**Application by Rosefield Energyfarm Limited for an order granting development consent for the Rosefield**

**Solar Farm (EN010158)**

**RESPONSE TO EXAMINING AUTHORITY QUESTIONS DEADLINE 4**

**Claydons Solar Action Group (CSAG)**

TITLE:
APPENDIX 5A
GREEN AND BLUE INFRASTRUCTURE PARAMETERS
BUFFER WIDTHS - KEY PLAN

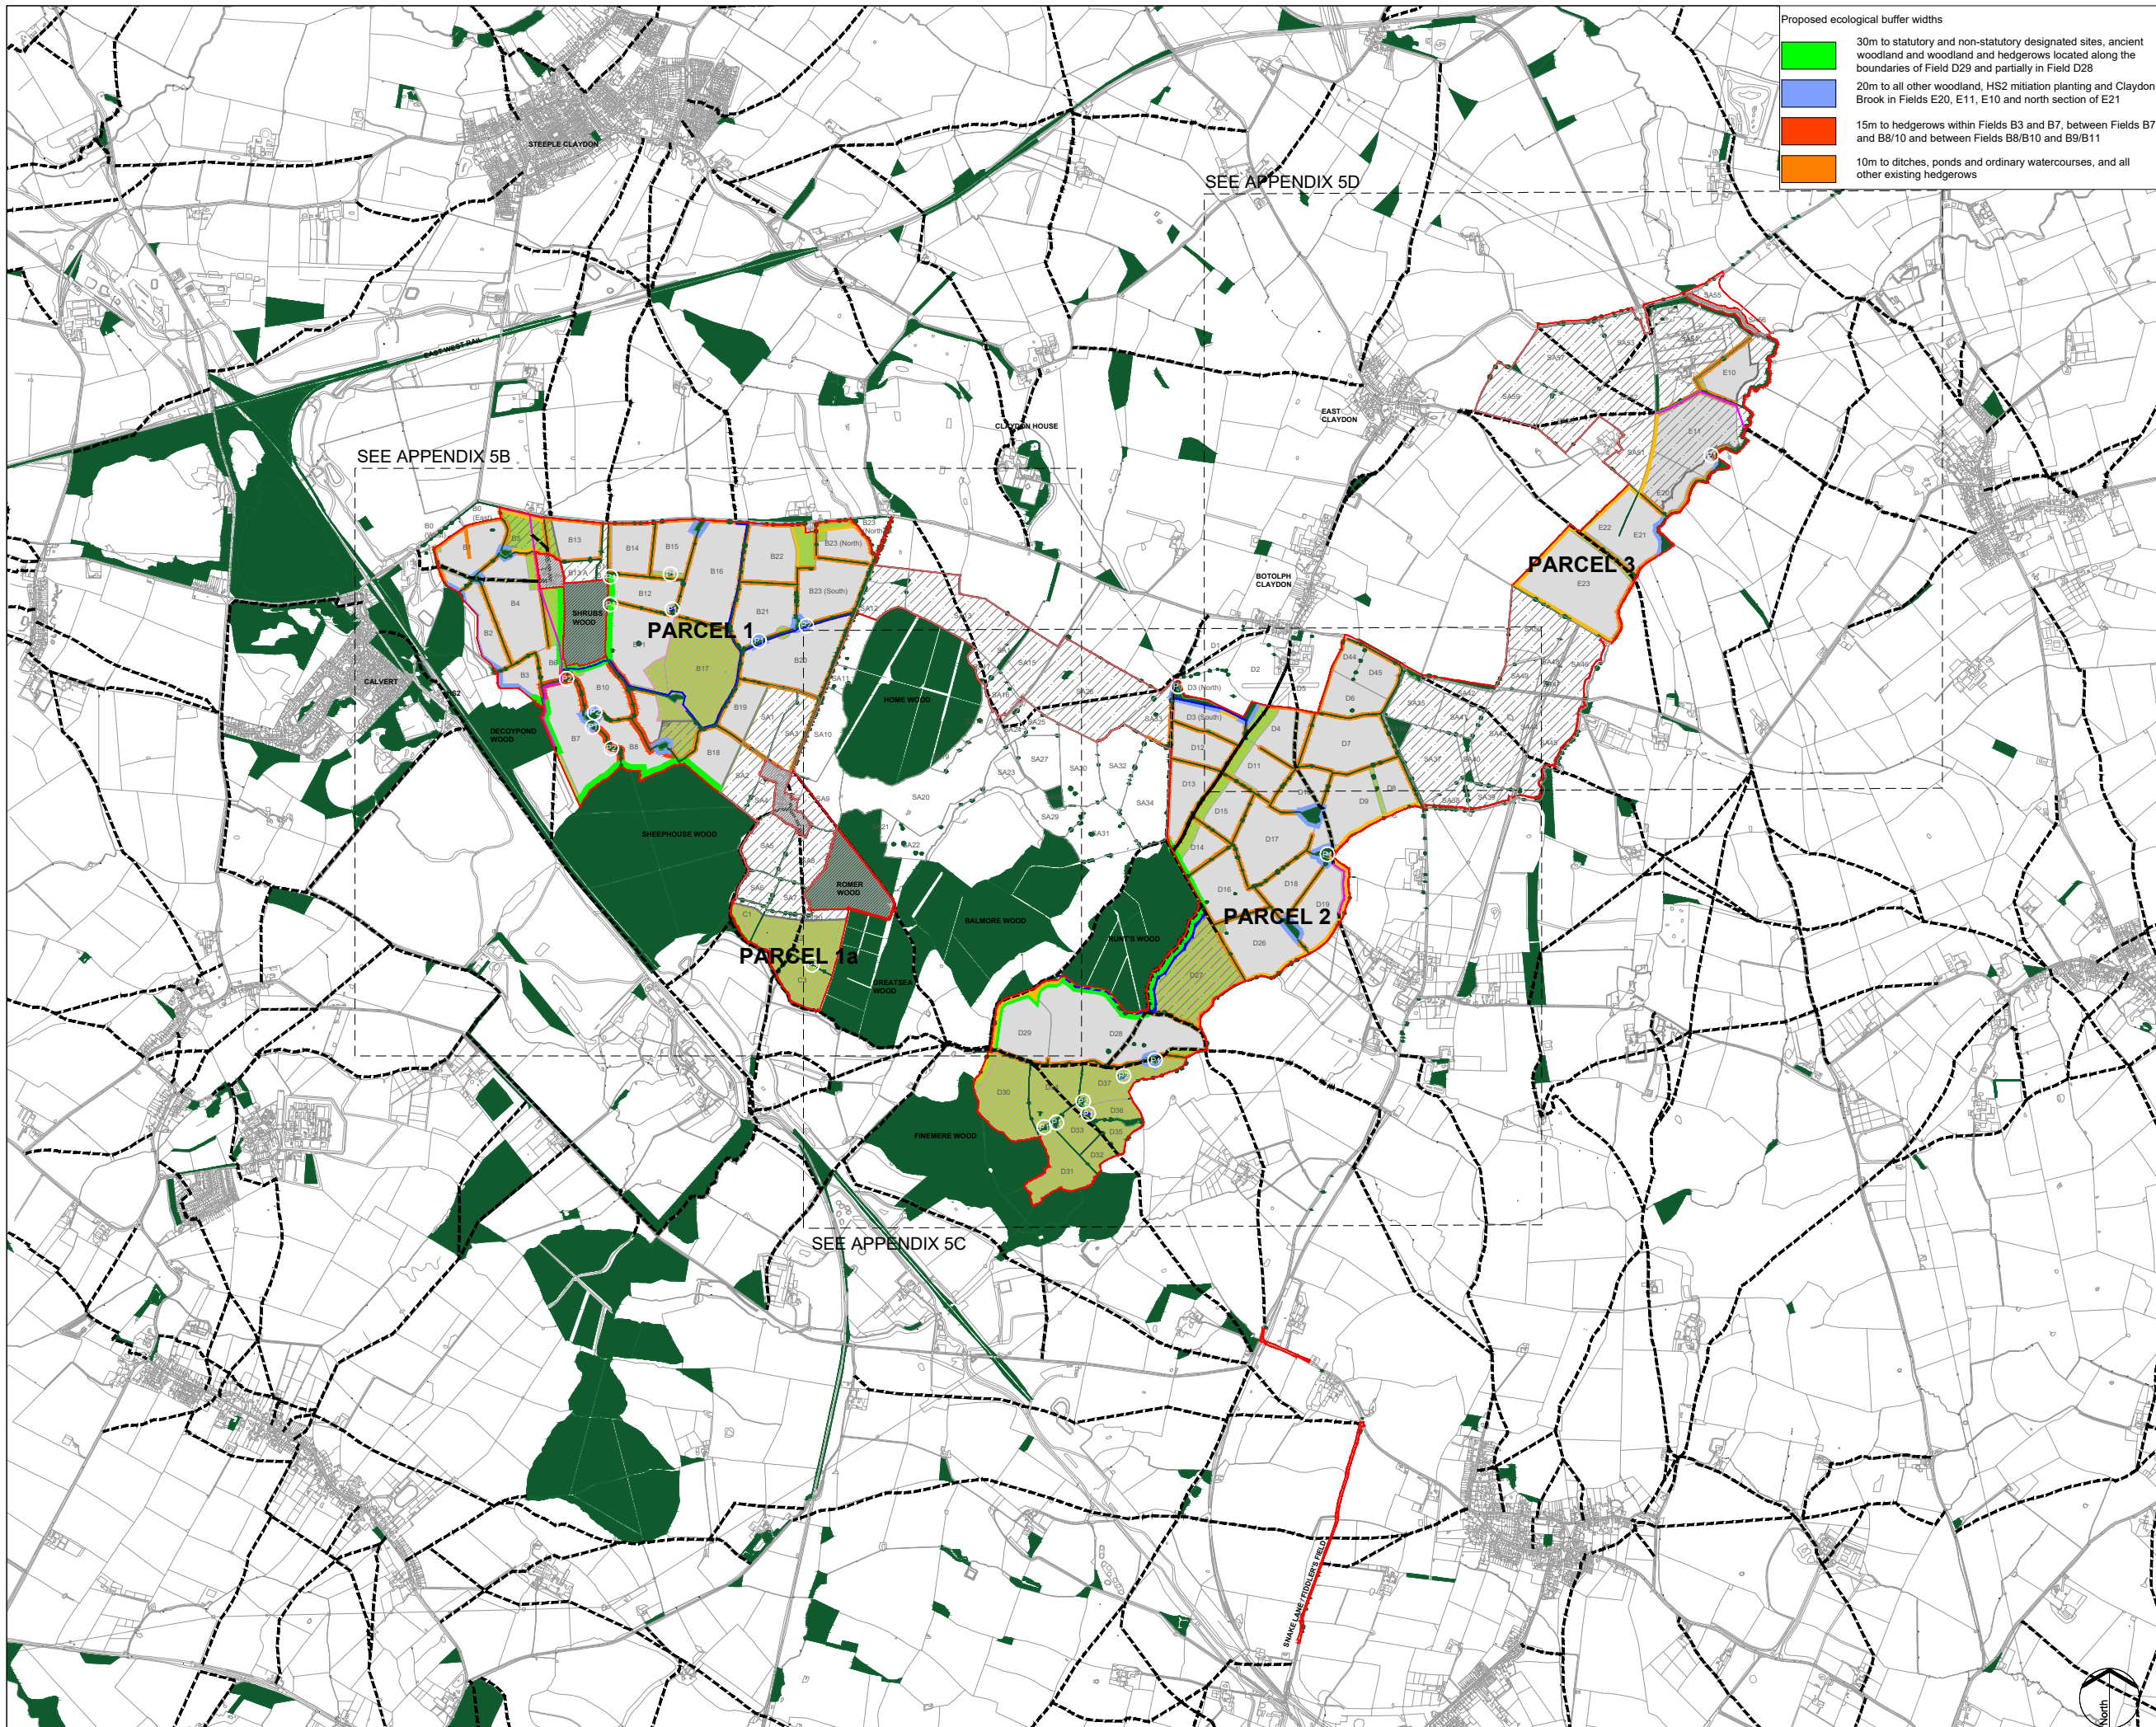
<p><i>certain and capable of consistent measurement over time.”</i></p> <p>1.4 CSAG consider that this is a contrived justification for using the centreline of hedgerows as the starting point for measuring buffers that wholly overlooks why such buffers are important and what their purpose is. It would be straightforward to measure the extant outer canopy line of existing hedgerow vegetation at a fixed and agreed point in time, using satellite imagery, and to mark out and/or plan around a set buffer distance from that line using GPS. CSAG wholly rejects the Applicant’s submissions on this matter, but also notes and welcomes Ms Stirling’s statement that the Applicant is prepared to consider the more ecologically rational alternative and its commitment to exploring “<i>a workable approach based on the baseline condition</i>” and “<i>scope for a practical solution between the parties, including potentially site-specific adjustments or bespoke buffer arrangements in key locations where ecological sensitivity is greatest</i>”.</p> <p>1.5 REP3-049 (p50-52) records Buckinghamshire Council’s concerns with the accuracy and adequacy of the BNG assessment and calculations. CSAG agrees with Buckinghamshire’s position on these points.</p>

## **Removal of Solar in B6, B7 & B8**

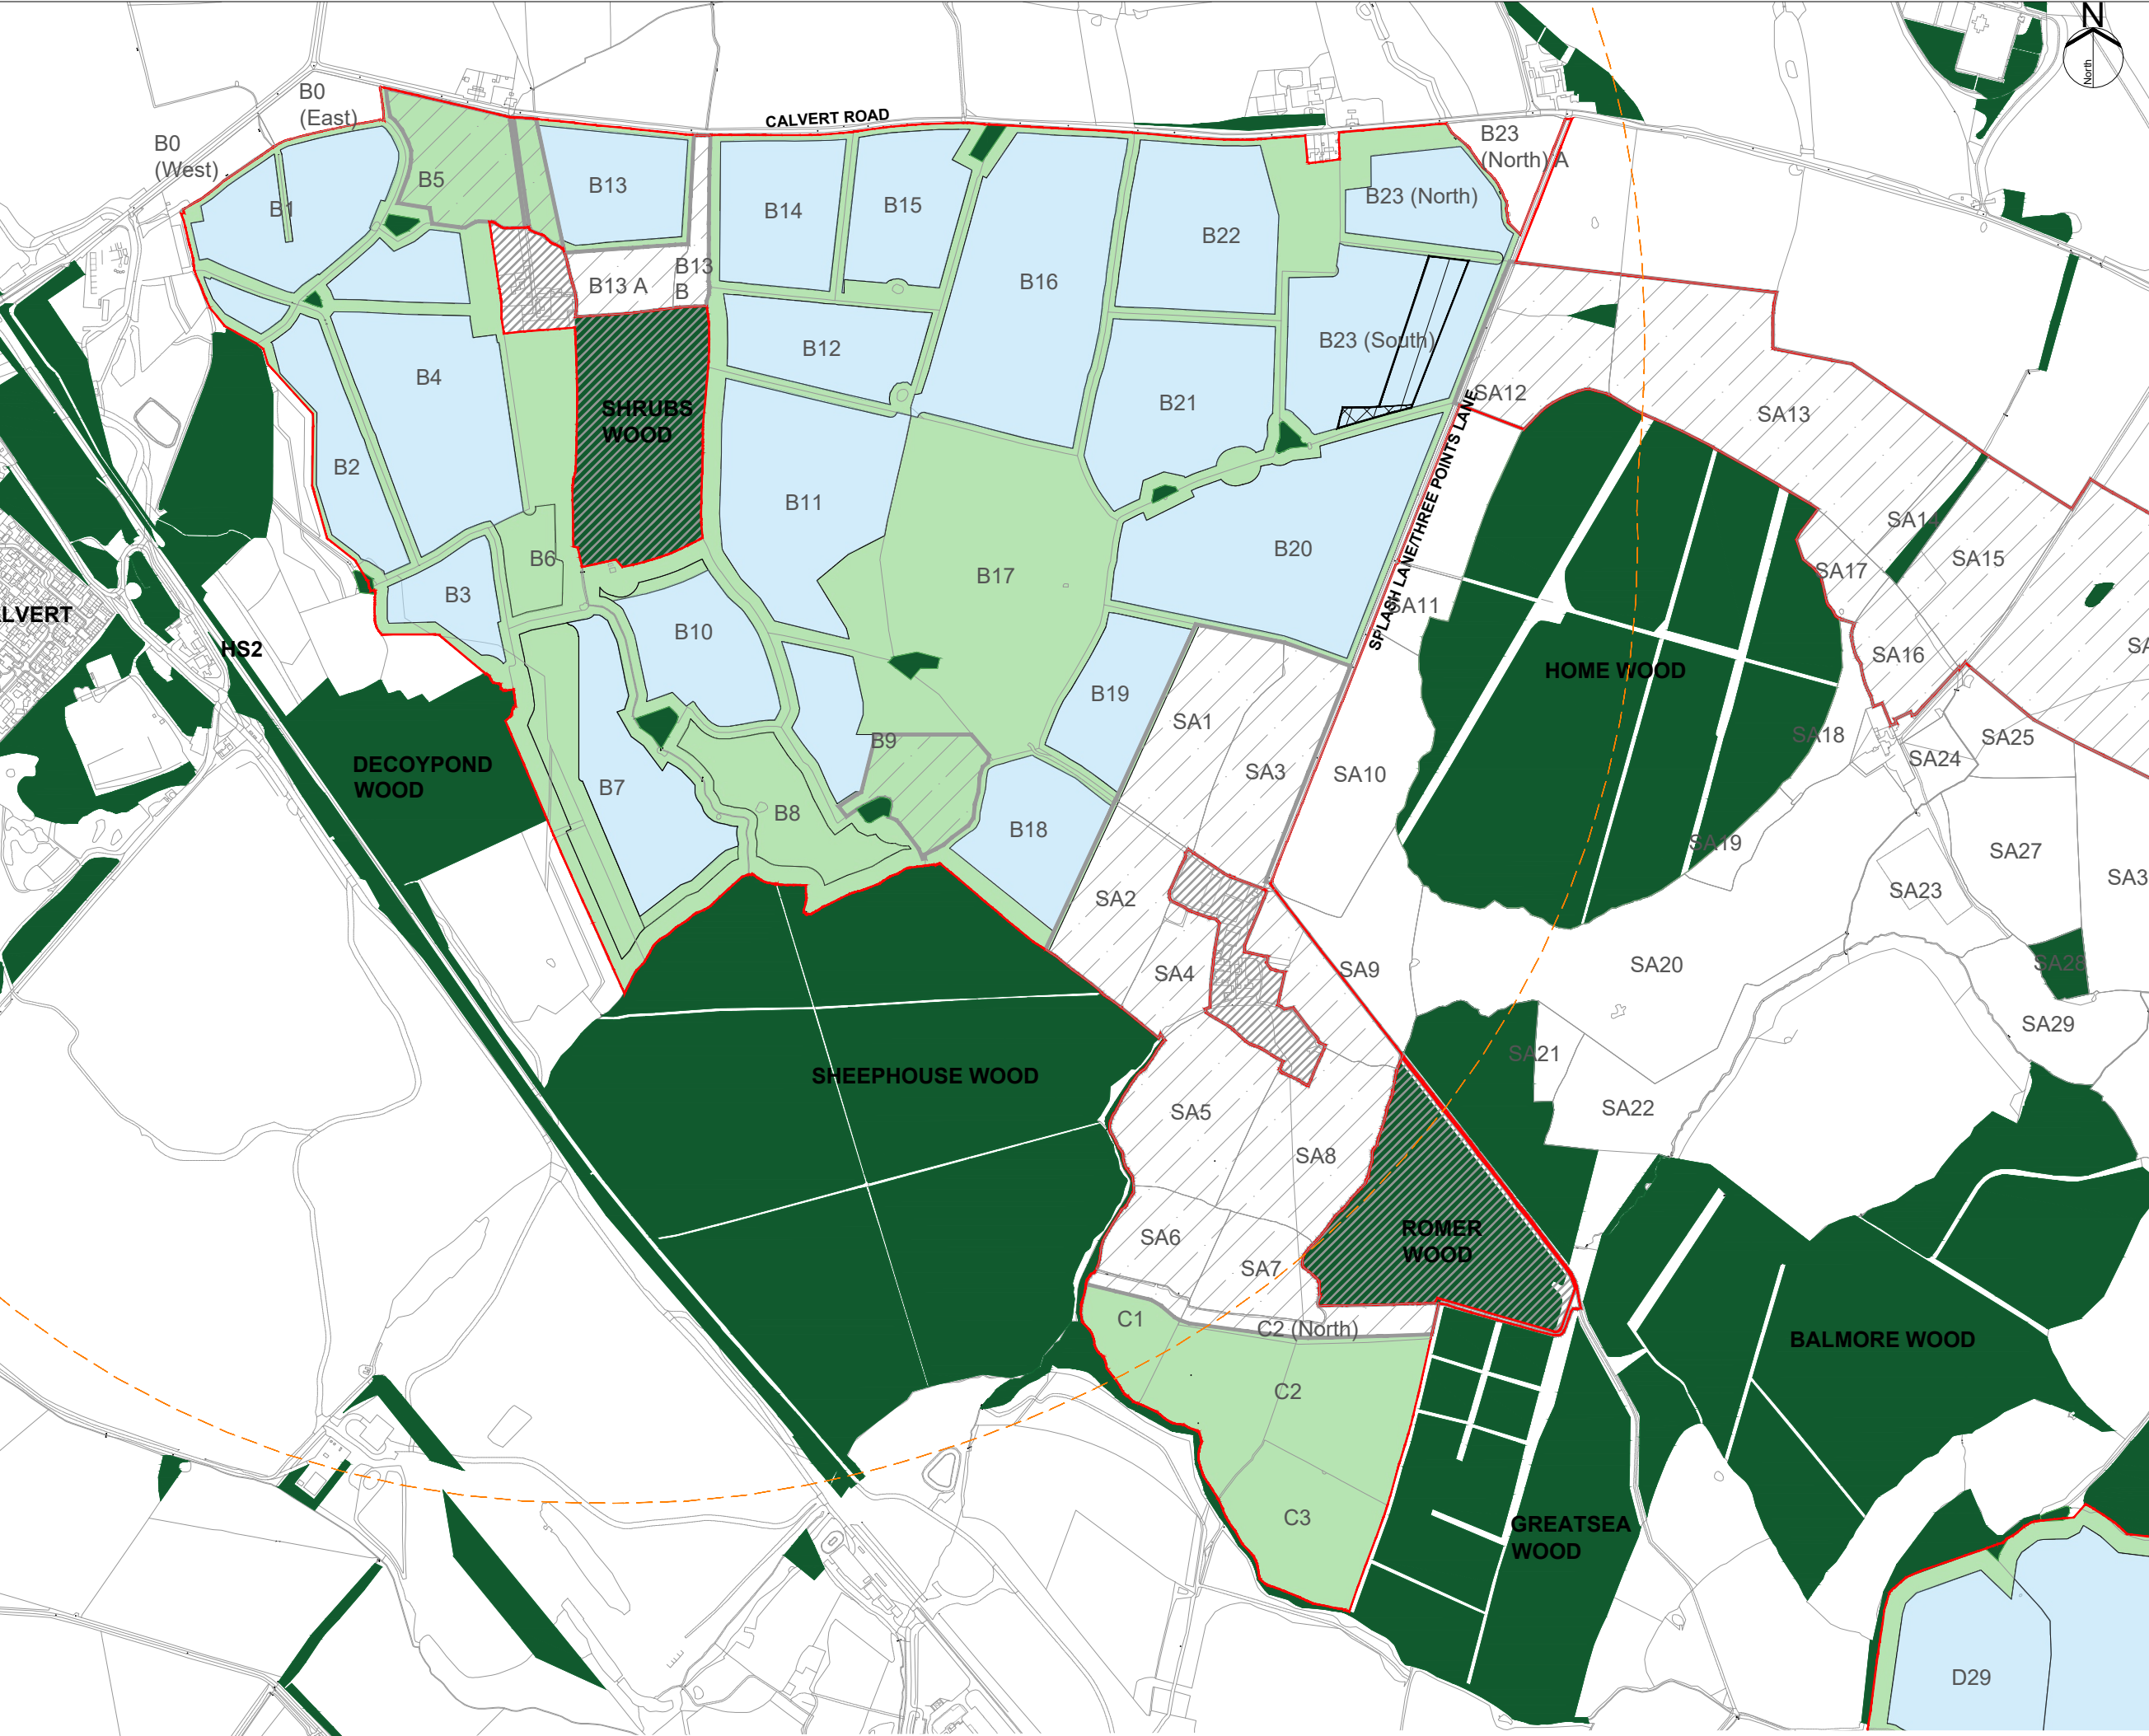
**B6, B7, B8**, which Natural England has asked be left free of development to protect the Bechstein bats.

CSAG agrees that all of these fields give rise to unacceptable adverse impacts and would like to see them removed from the scheme.
